Application No: 20/1723/PREAPP
Case Officer: Jade Harbottle
Direct line: 01642 528716

Date: 25 September 2020

Proposal: Detached garage to side, erection of fence to front and extended driveway

Location: 2 Garth Close, Carlton, Stockton-on-Tees

SHEET	0001	SCALE	1:100 @ A1
2 GARTH CLOSE			
GENERAL ARRANGEMENT OF NEW EXTERNAL TIMBER GARAGE + LEAN TO			
DWG NO	BM-2020-06-0001

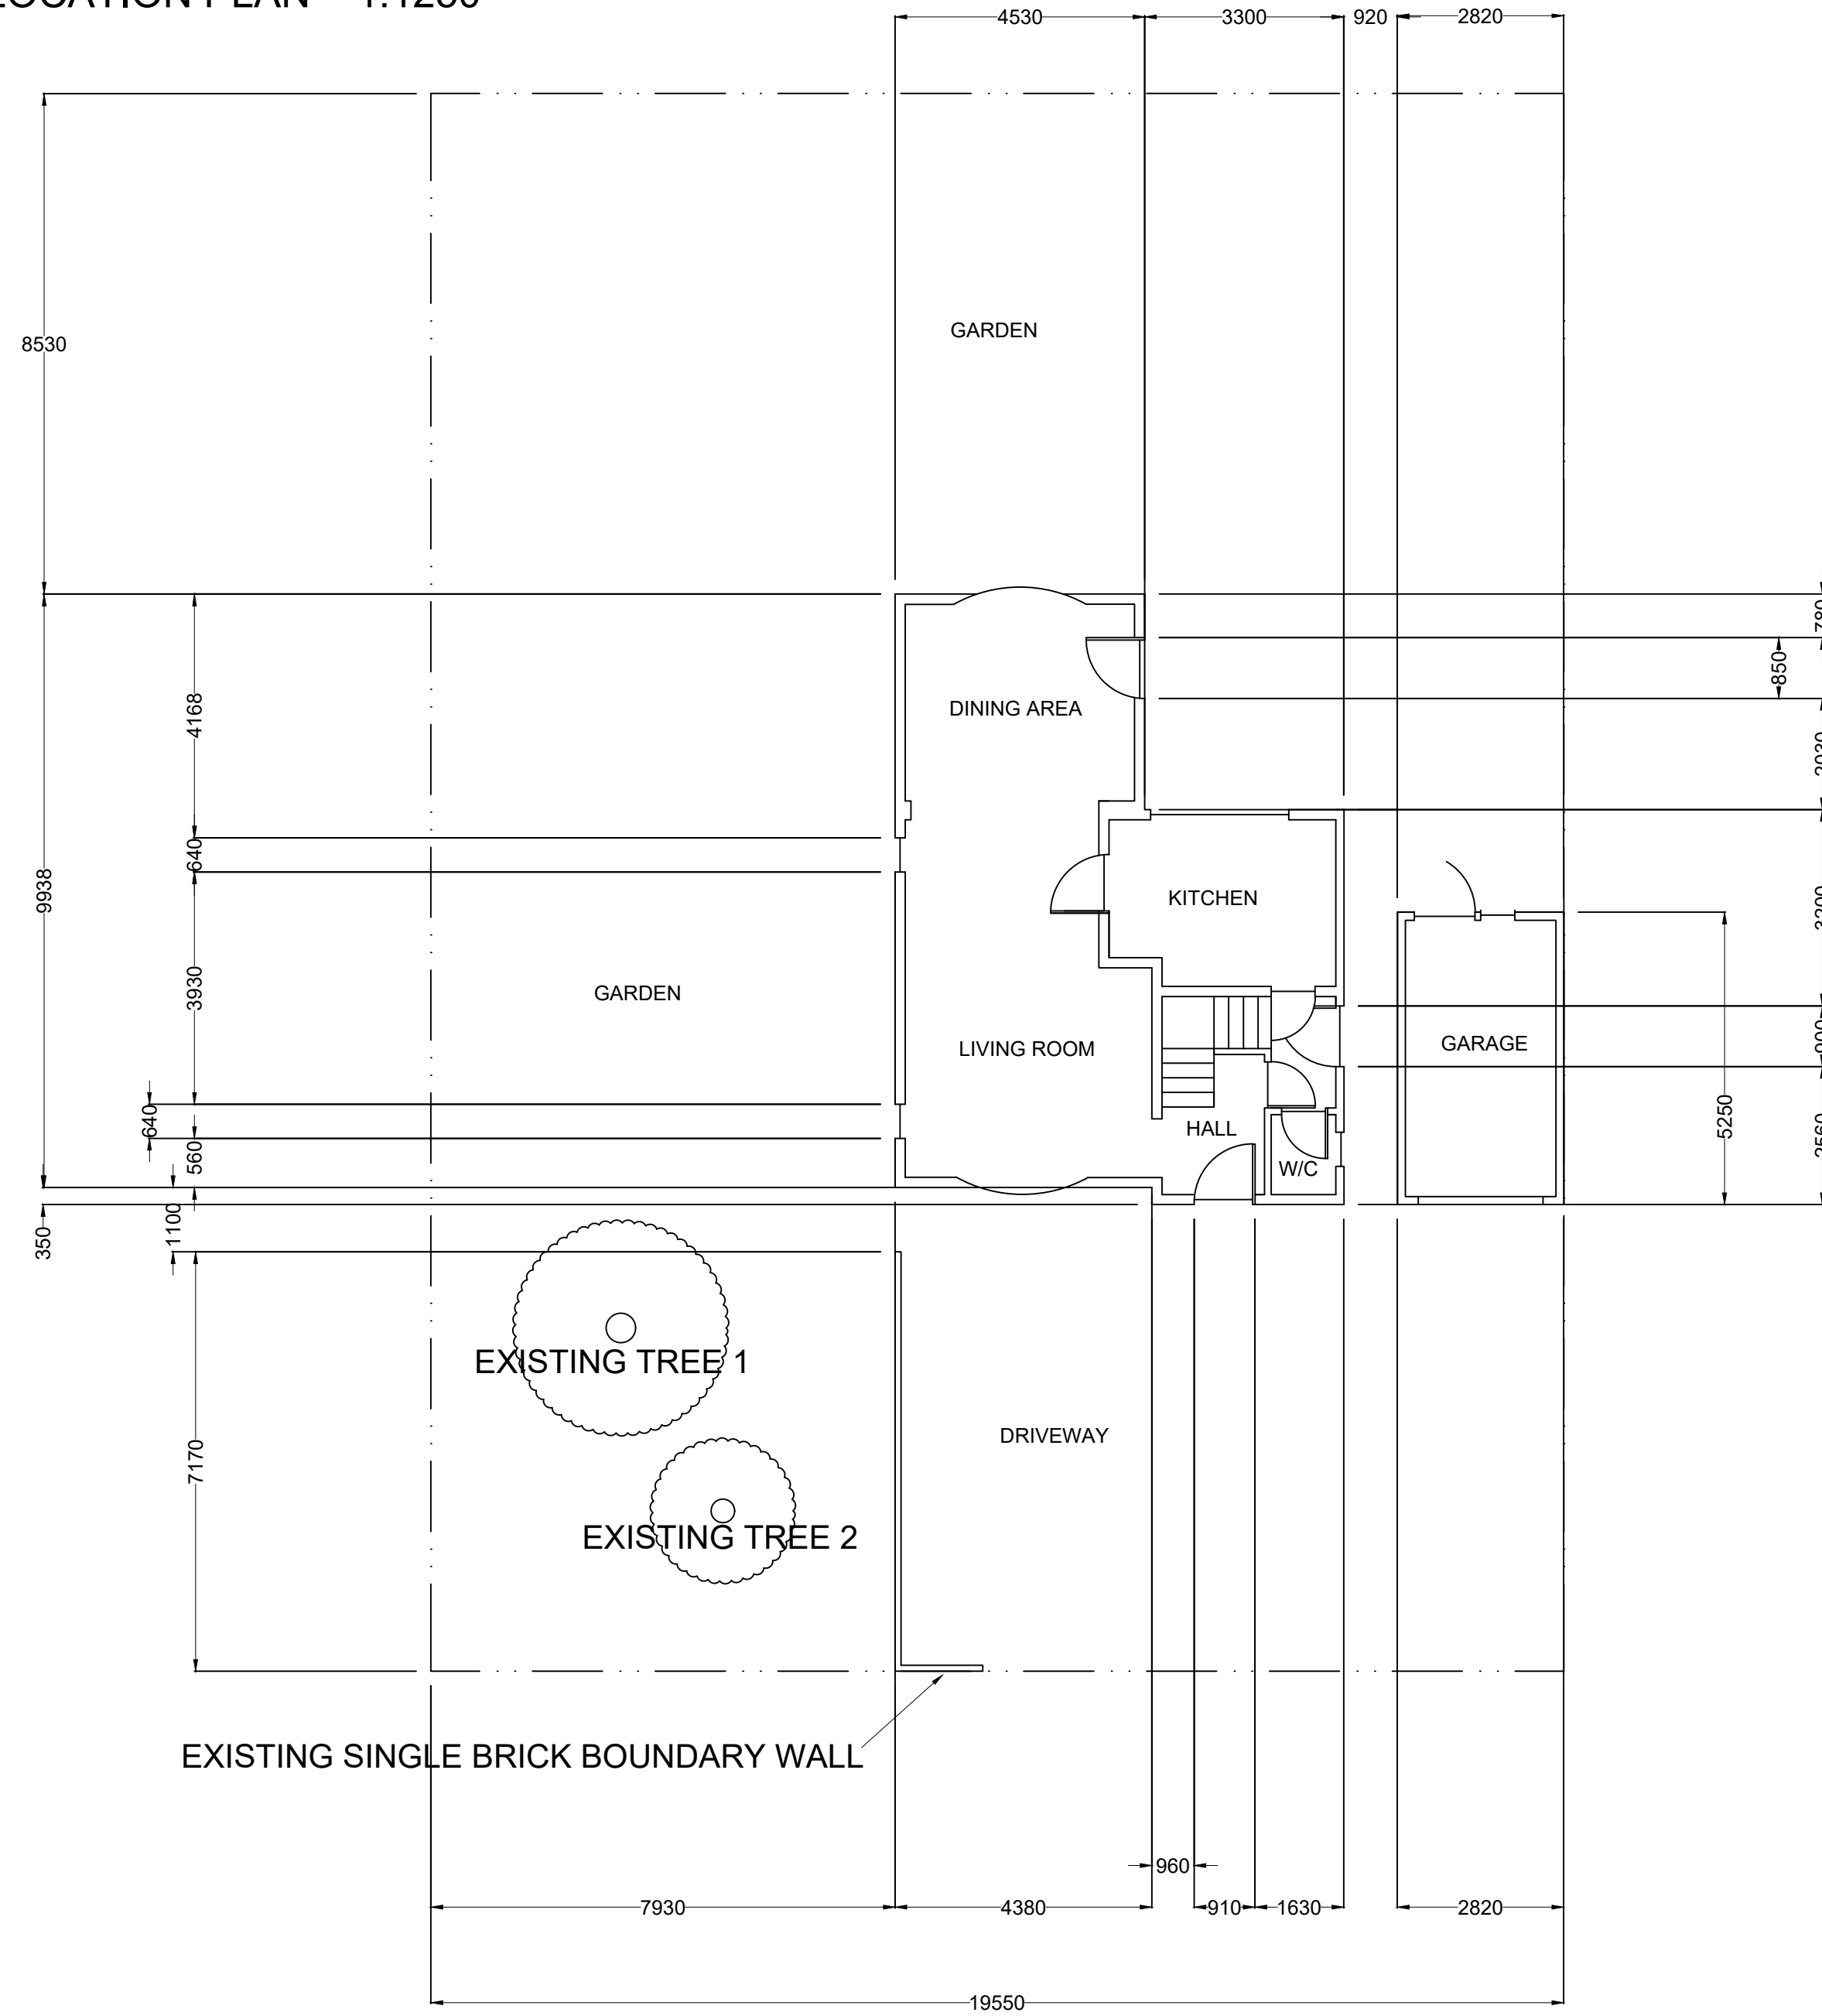
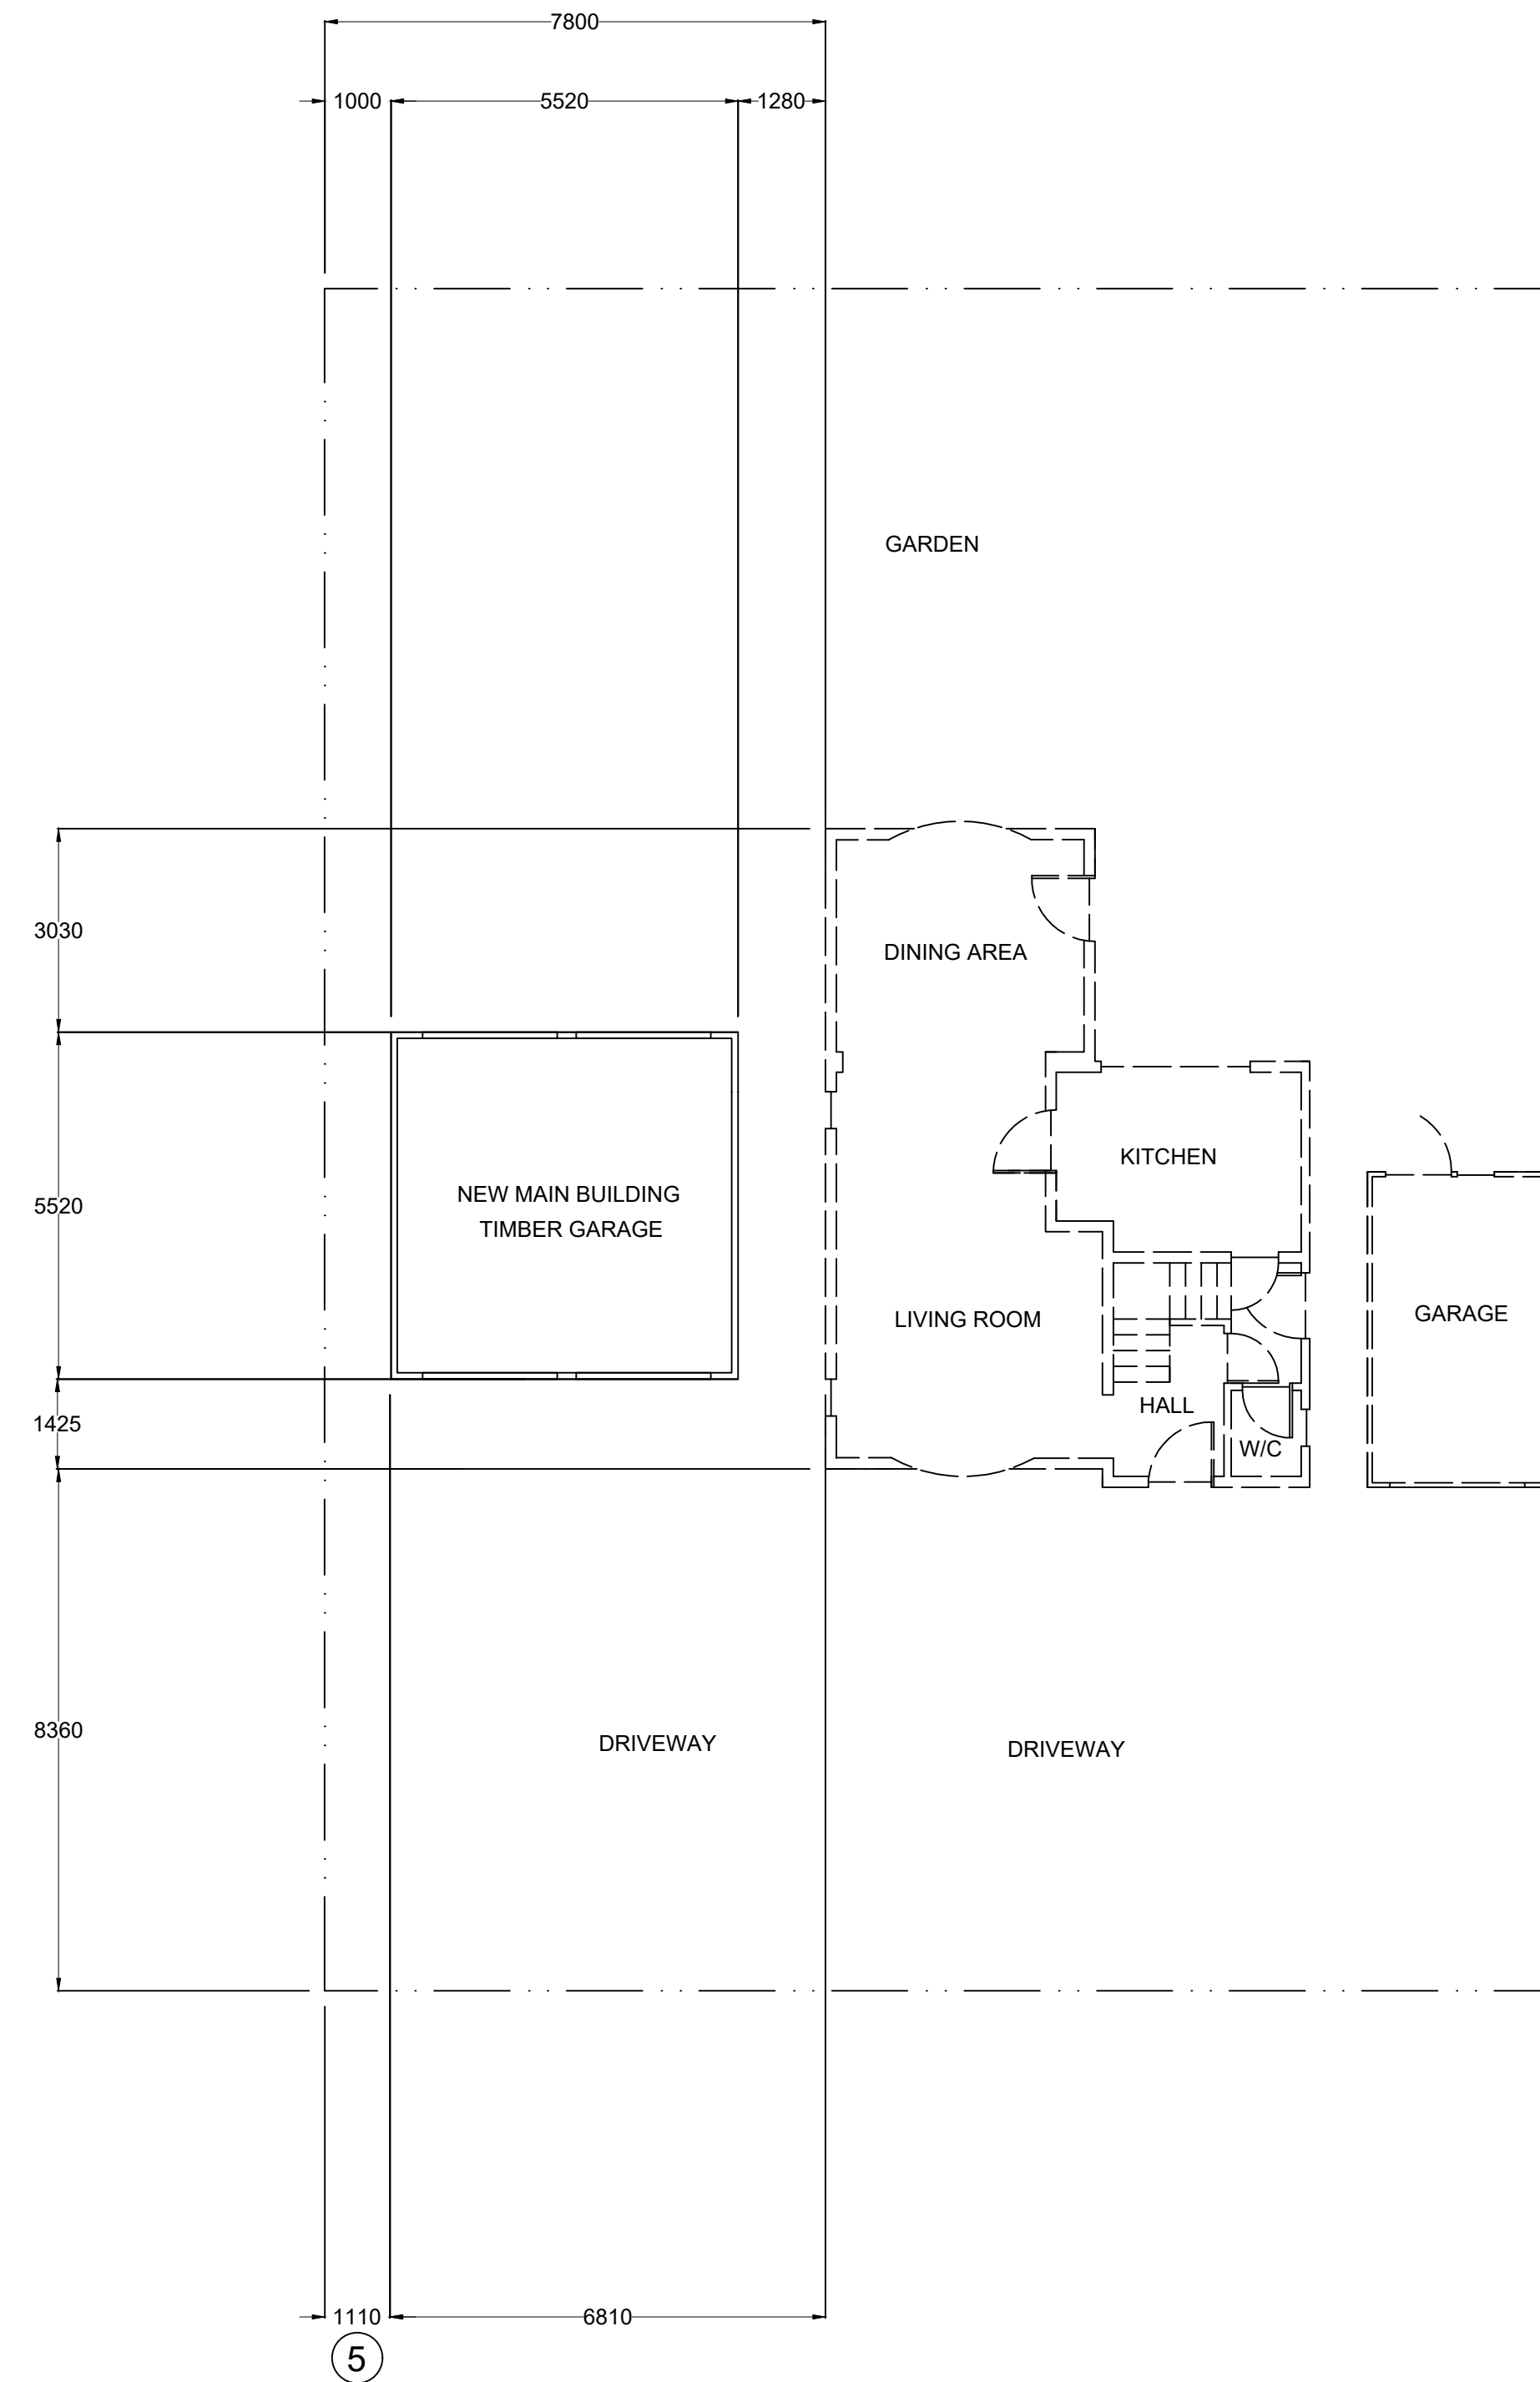
Further to your enquiry there are three elements to your enquiry and from the attached information it appears the garage and driveway would likely fall with the permitted development criteria however for the avoidance of doubt I have set out each criteria below;

With regards to the fence, you can erect up to 2 metres high on the east elevation continuing on from the existing wall providing it does not extend forward from an imaginary line drawn from the wall of the existing garage closest to the property across the front garage area (shown on your images). Approximately 2 metres set back from the highway. The fence and gates shown across the front garden area however cannot exceed 1 metre in height as planning permission would be required. Should an application be received for the erection of an enclosure greater than 1 metre in height at the front, the considerations of the application would be highway safety/manoeuvrability and impact upon the character of the street scene and residential amenity. The cul-de-sac does not currently benefit from boundary enclosures to the front and should an application be received it may be resisted given the character of the street scene and may end up at planning committee.
